CITY OF ALBUQUERQUE

**Re: Innova Plaza
Grading and Drainage Plan
Engineer's Date 9-2-14 (L20D067)**

Based upon the information provided in your submittal received 9-3-14, the above referenced plan is not approved for Grading Permit or Building Permit until the comments below are addressed.

CG-101

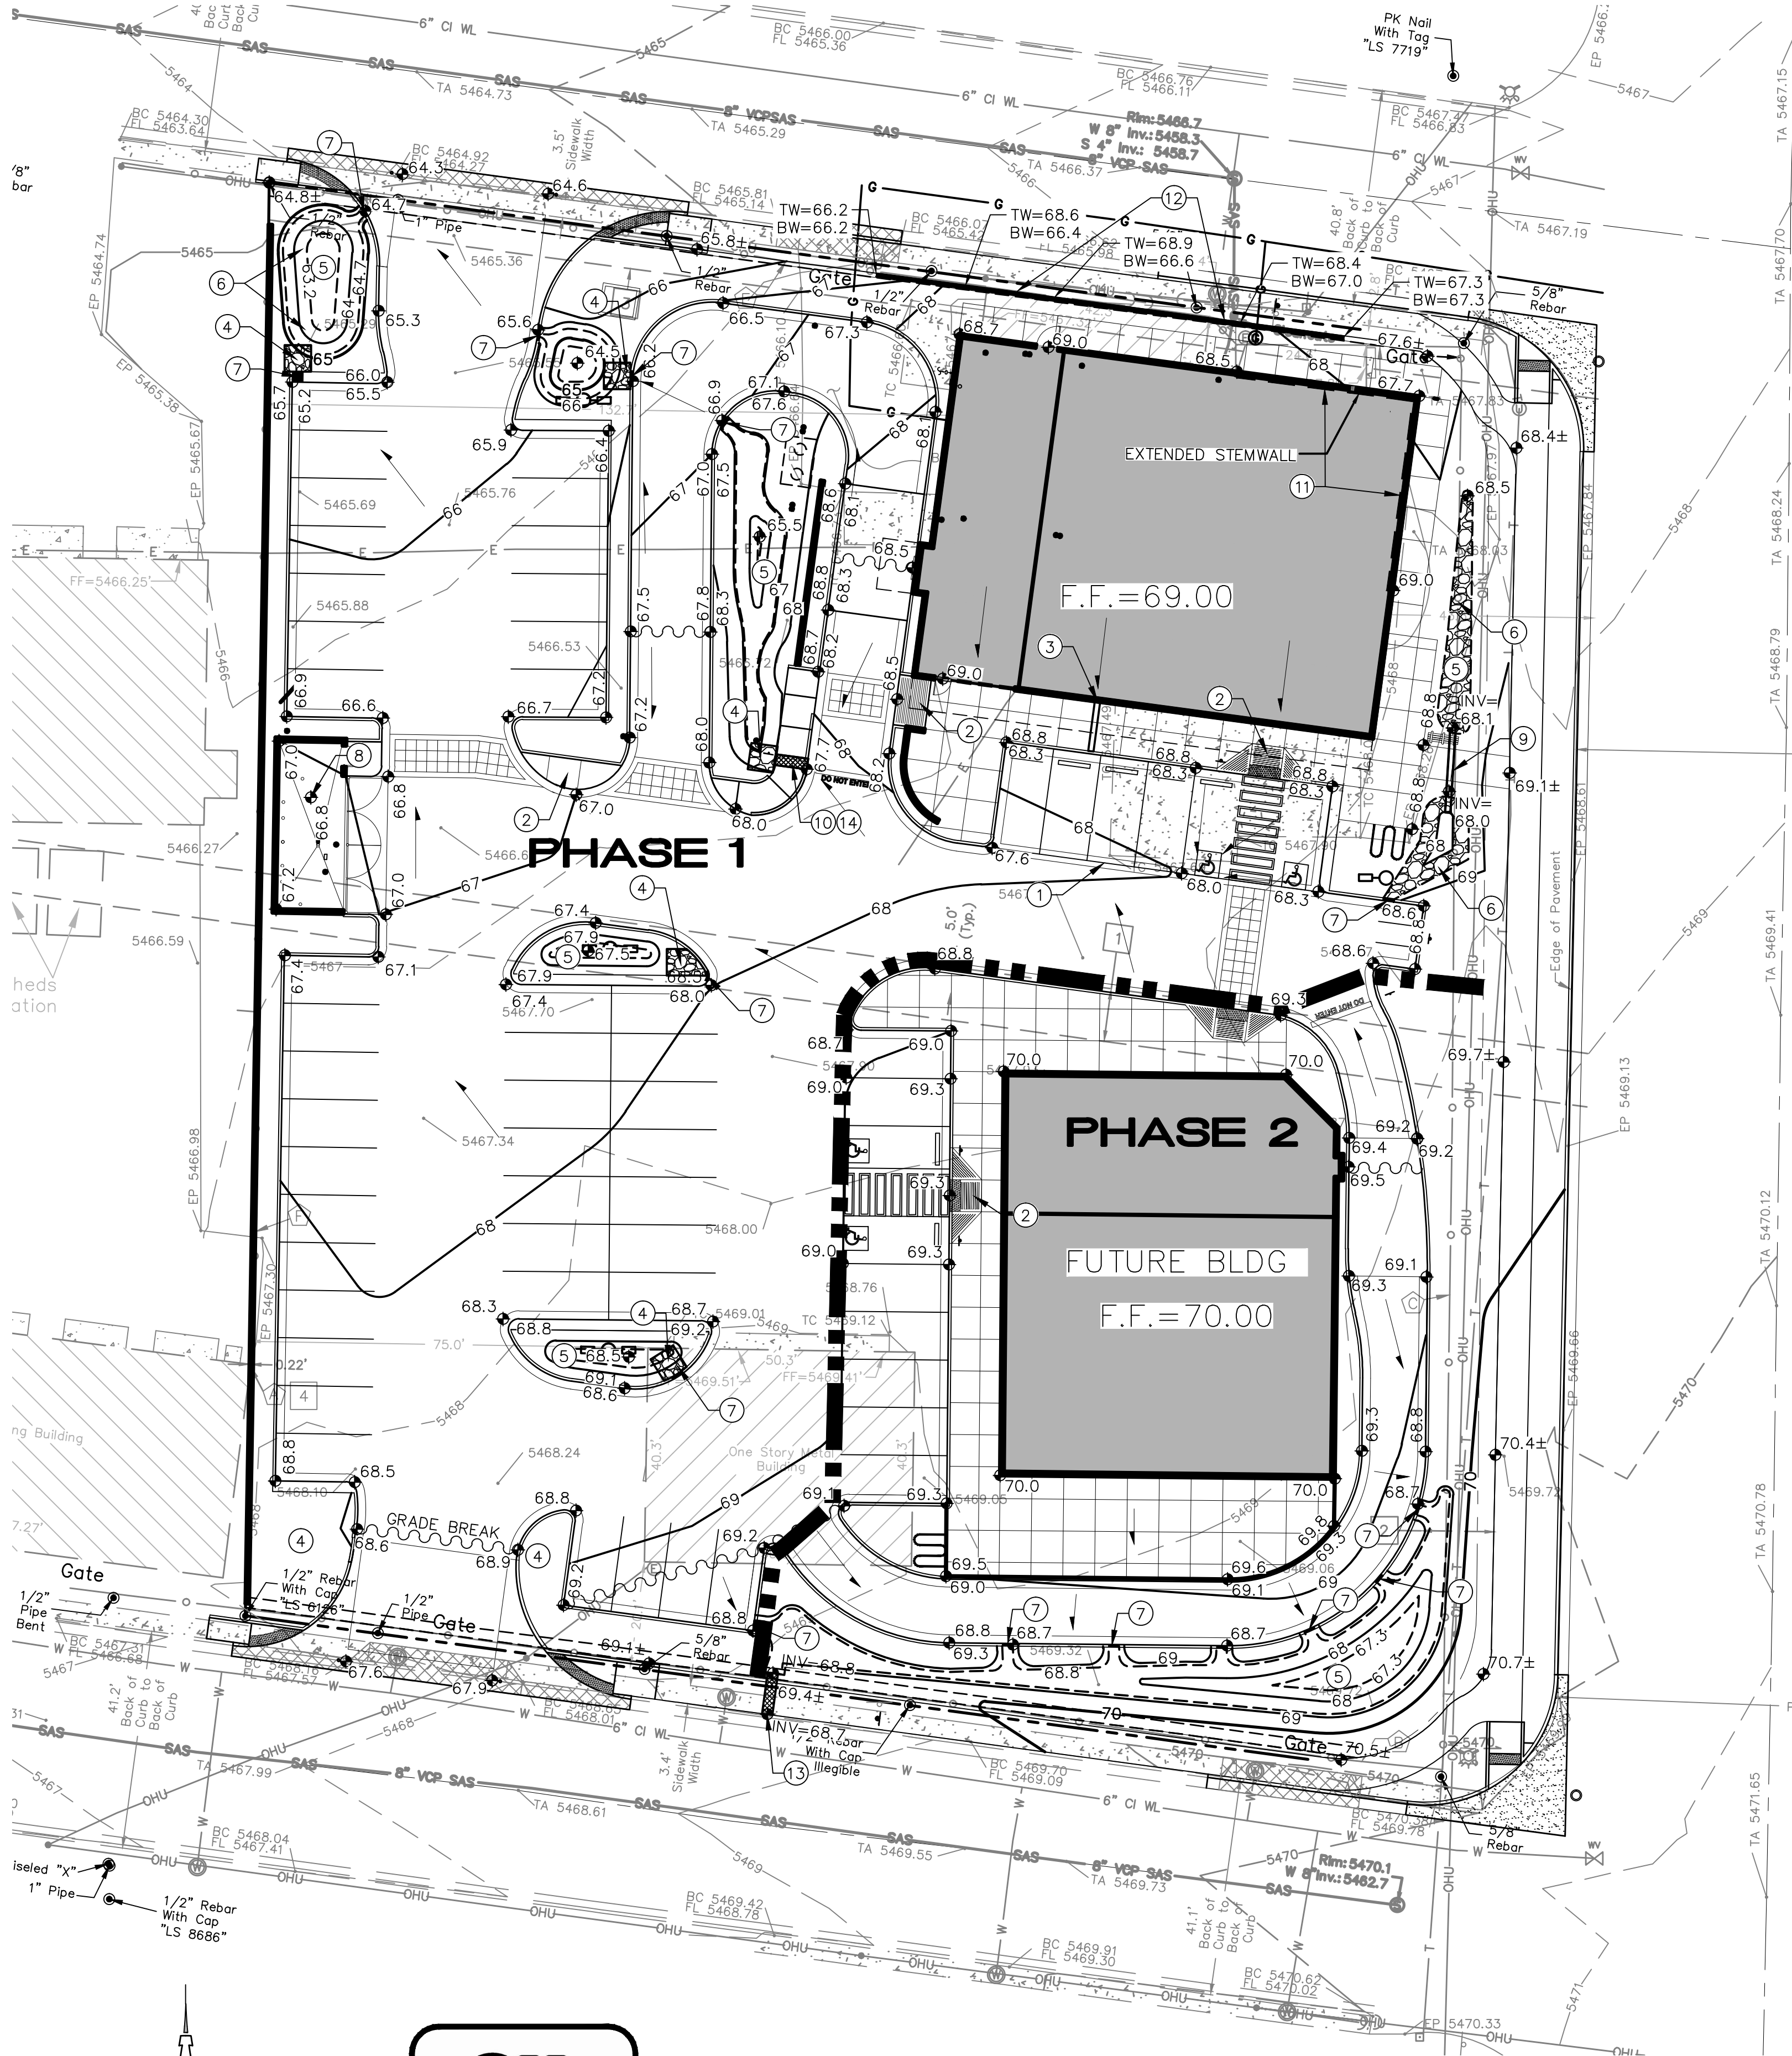
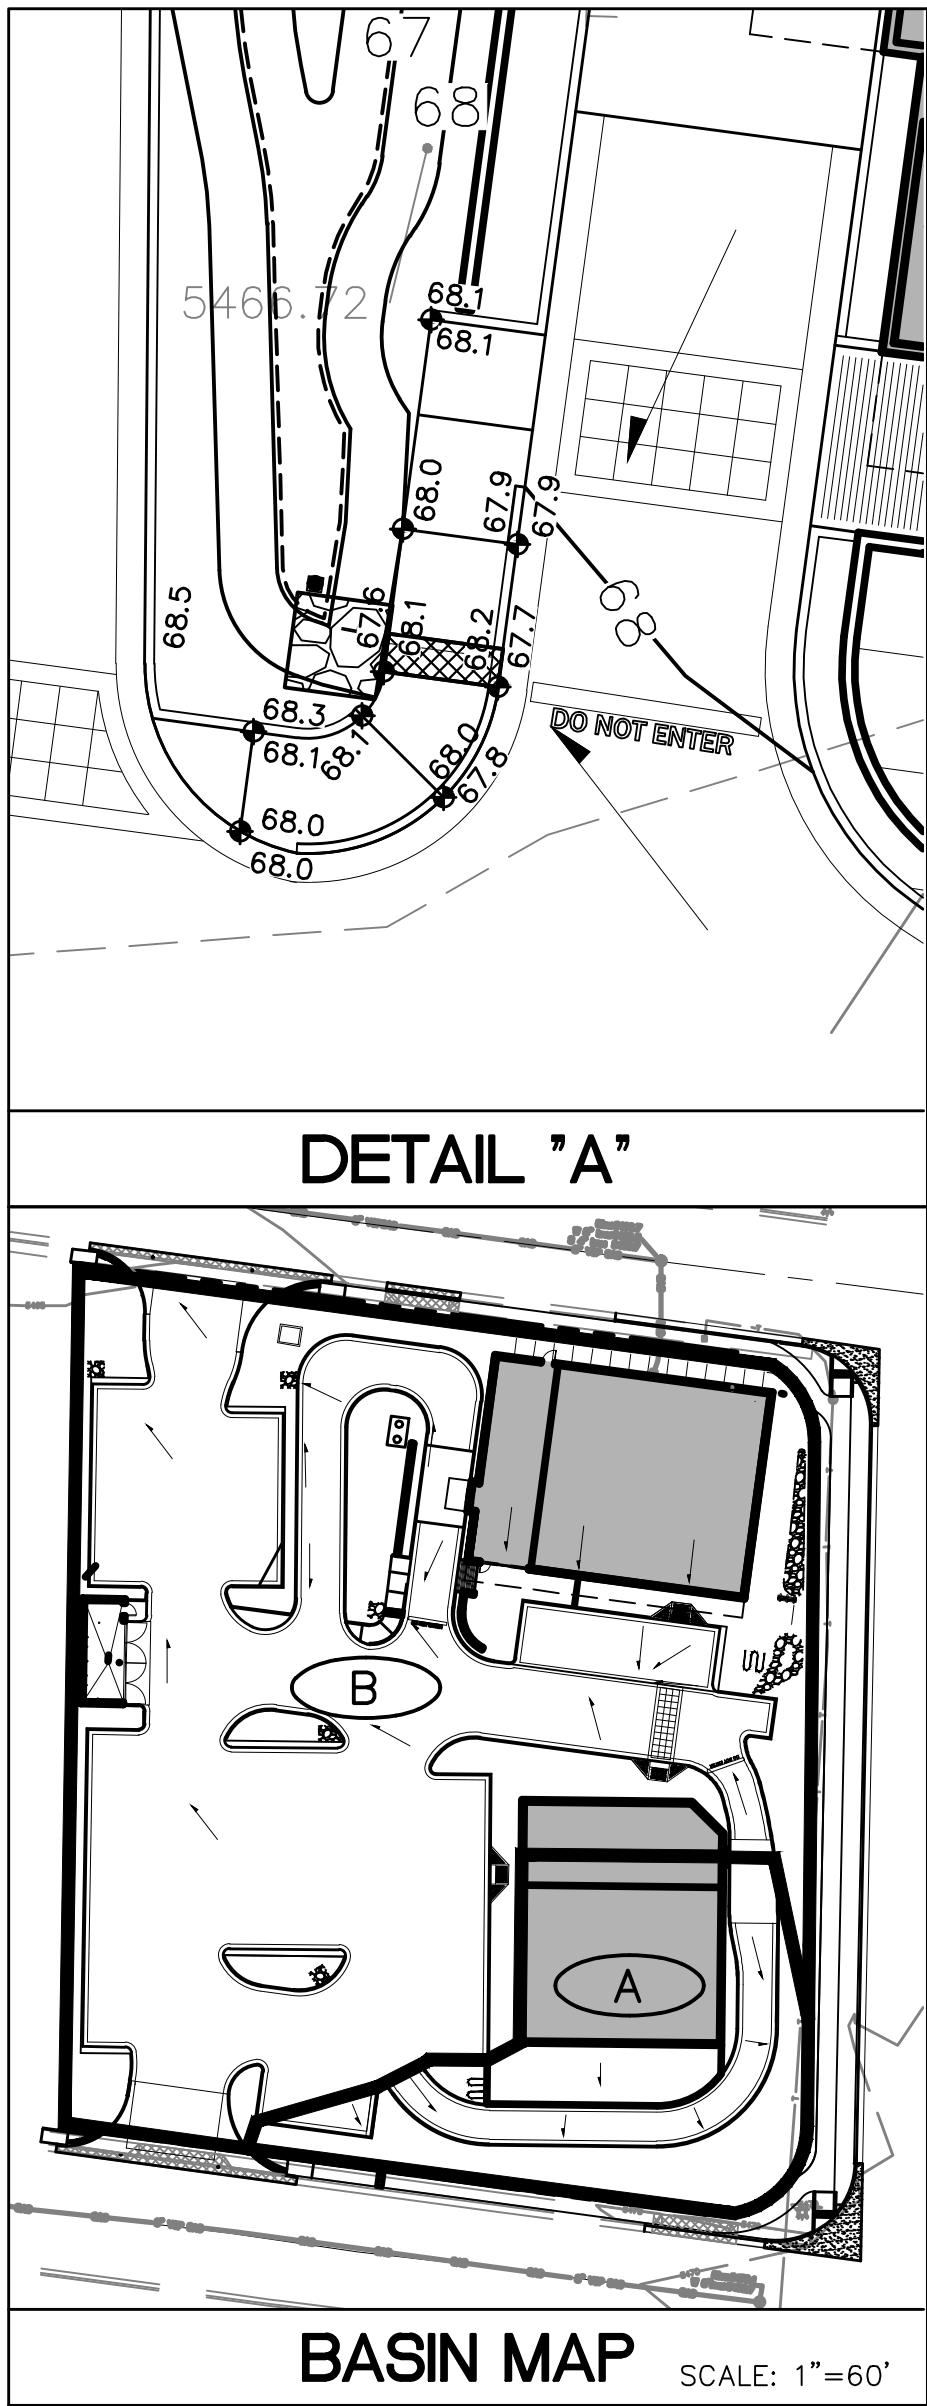
1. Water harvesting ponds have been provided with the design. Provide retention for the First Flush. Include a narrative about the First Flush (remove references to water harvesting) and the amount being retained by the ponds. Per the City Drainage ordinance, the 90th Percentile Storm Event, which is 44 inches, is to be managed. Reduce 0.44 inch by the 0.1 inch for the initial impervious abstraction in Table A-6 of Section 22 of the DPM. Multiply the remaining 0.34 inch by your impervious area. This is the portion to retain.
2. What portion of the plan will be completed with the first building? All drainage improvements must be completed with the first building. Indicate that on the plans as well.
